Application No: A/67/26/DOC
Site Address: Rustington Golf Centre Golfers Lane Angmering BN16 4NB
Description of works: Approval of details reserved by condition under A/129/21/PL (Appeal ref: APP/C3810/W/22/3298192) relating to condition 7- Public Open Space and Play Areas.

Thank you for your internet representation made on 24th June 2026 which has been recorded as no objection with the comments as follows:

SHEET TITLE: South LEAP

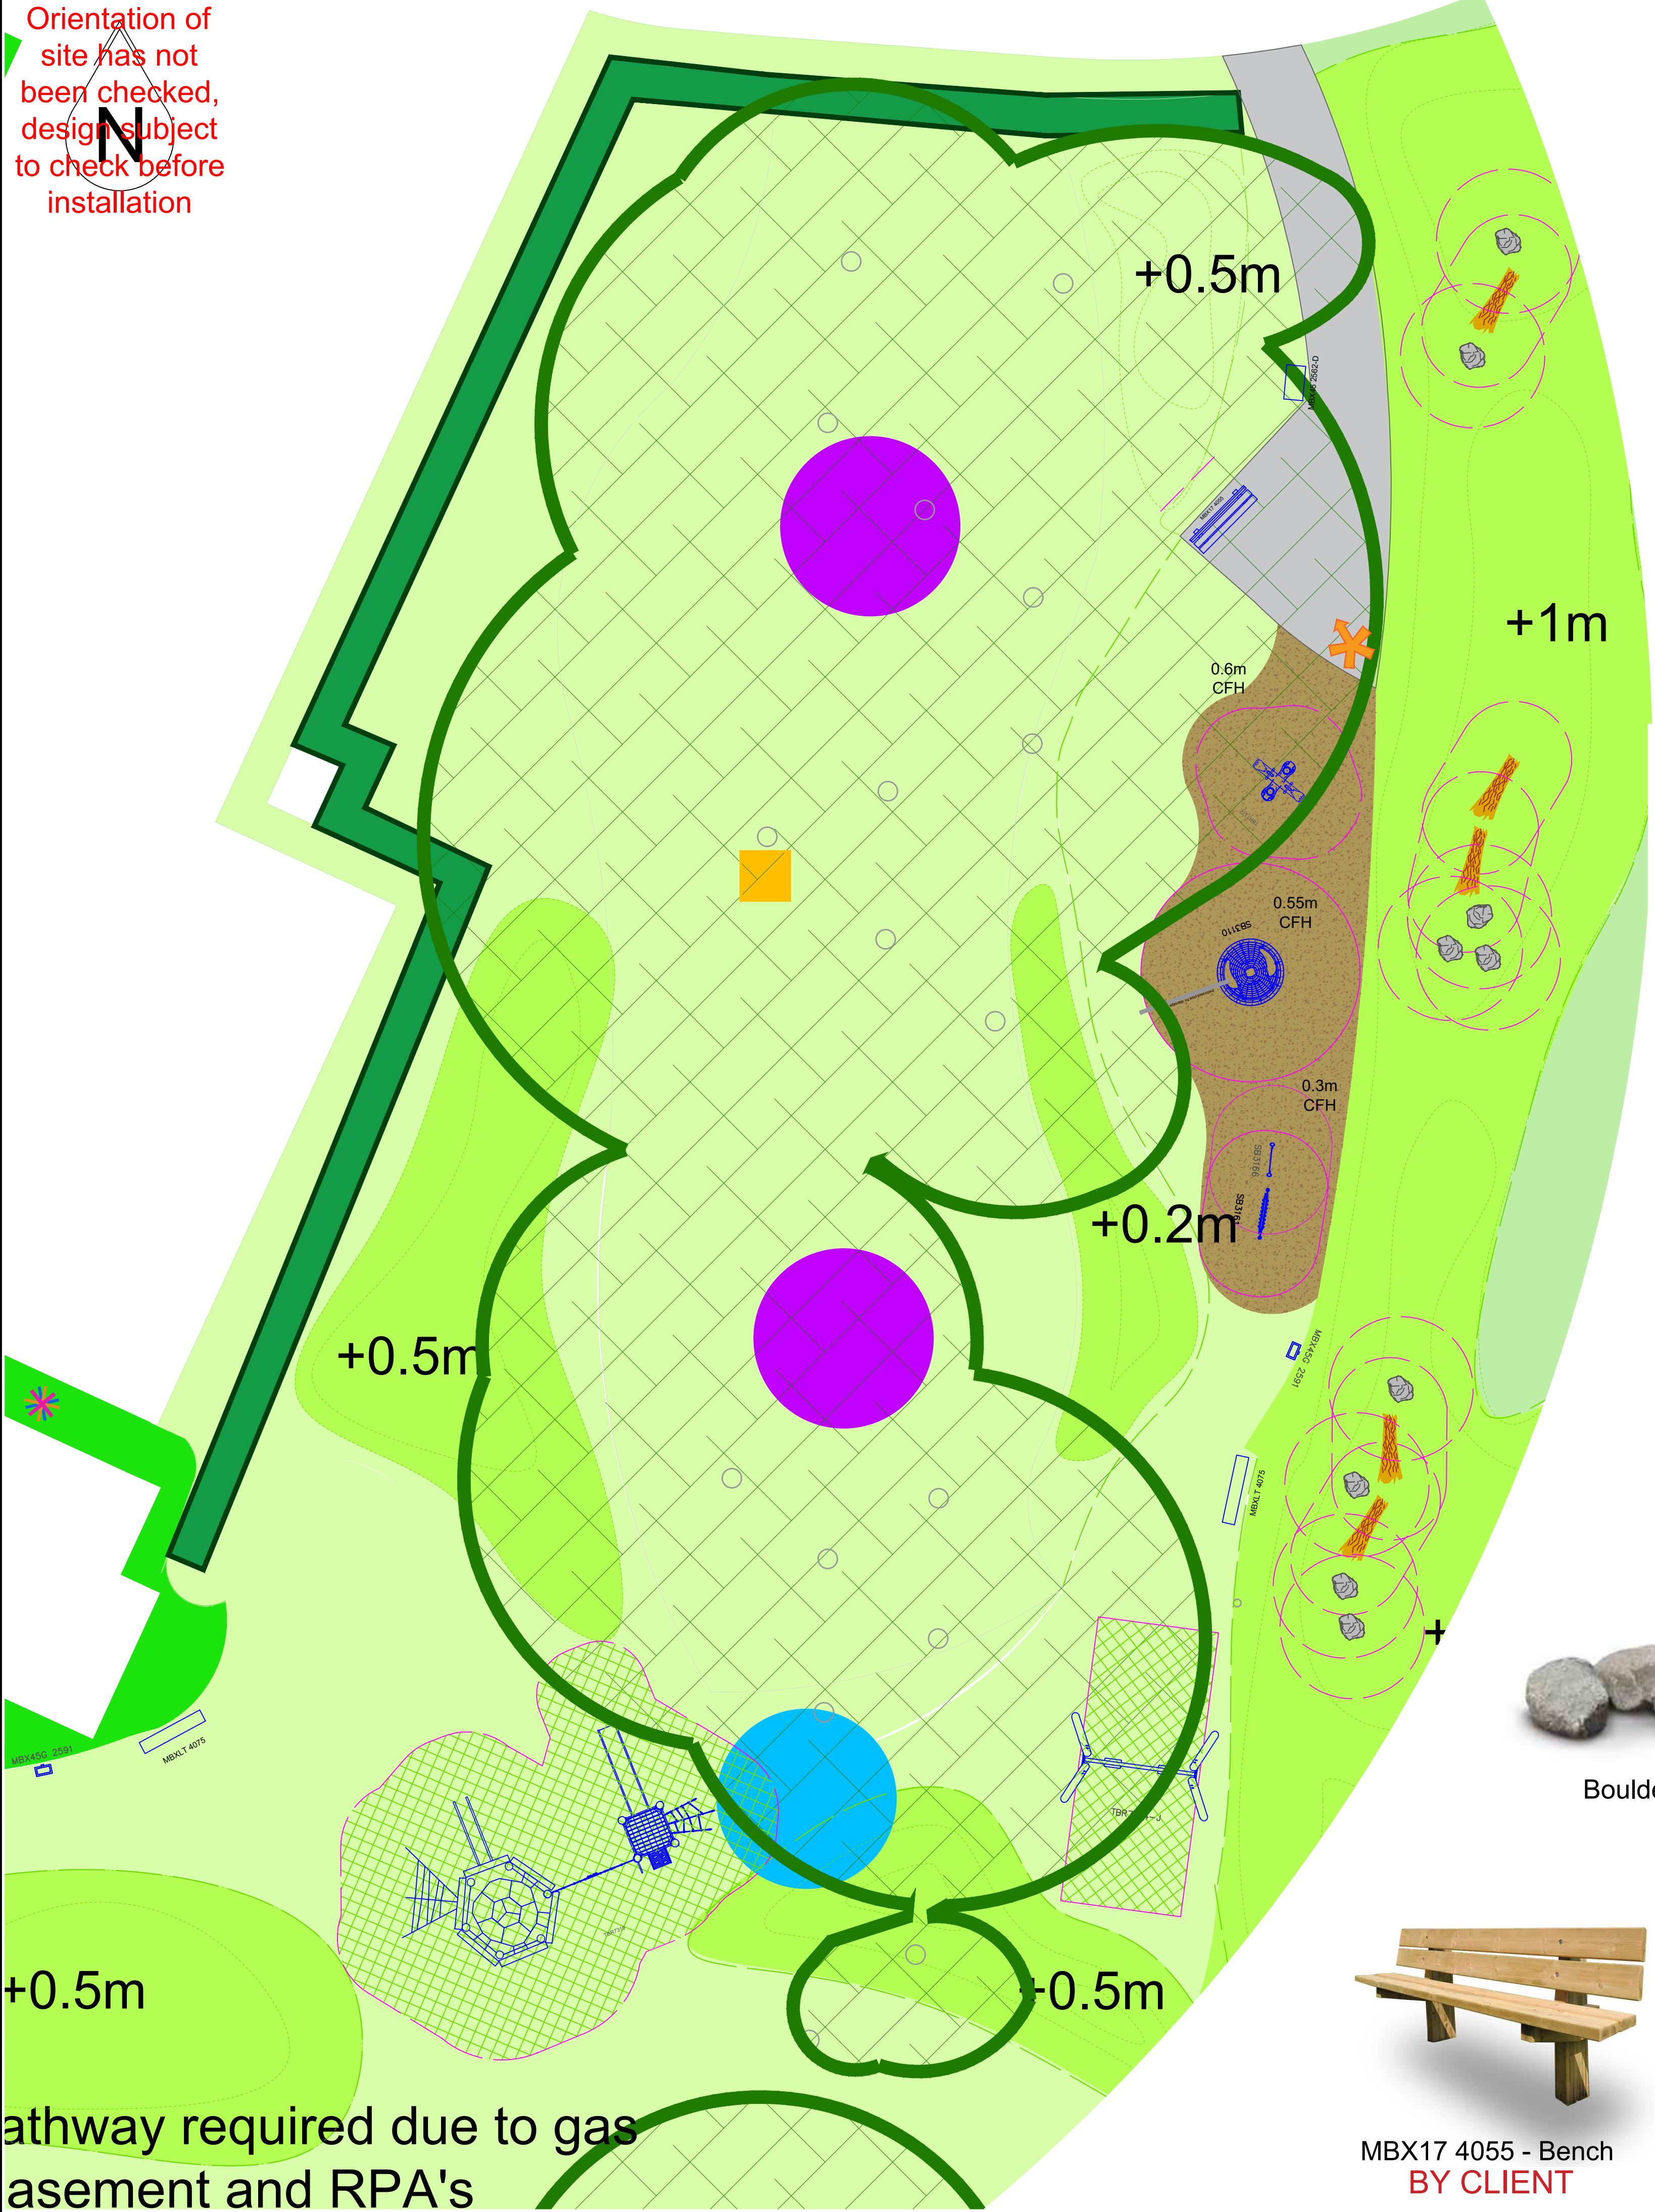
Whilst APC has no objection to the play equipment, it does have concerns regarding the boulders and requests that they are securely fixed to each other and the ground and therefore immovable.
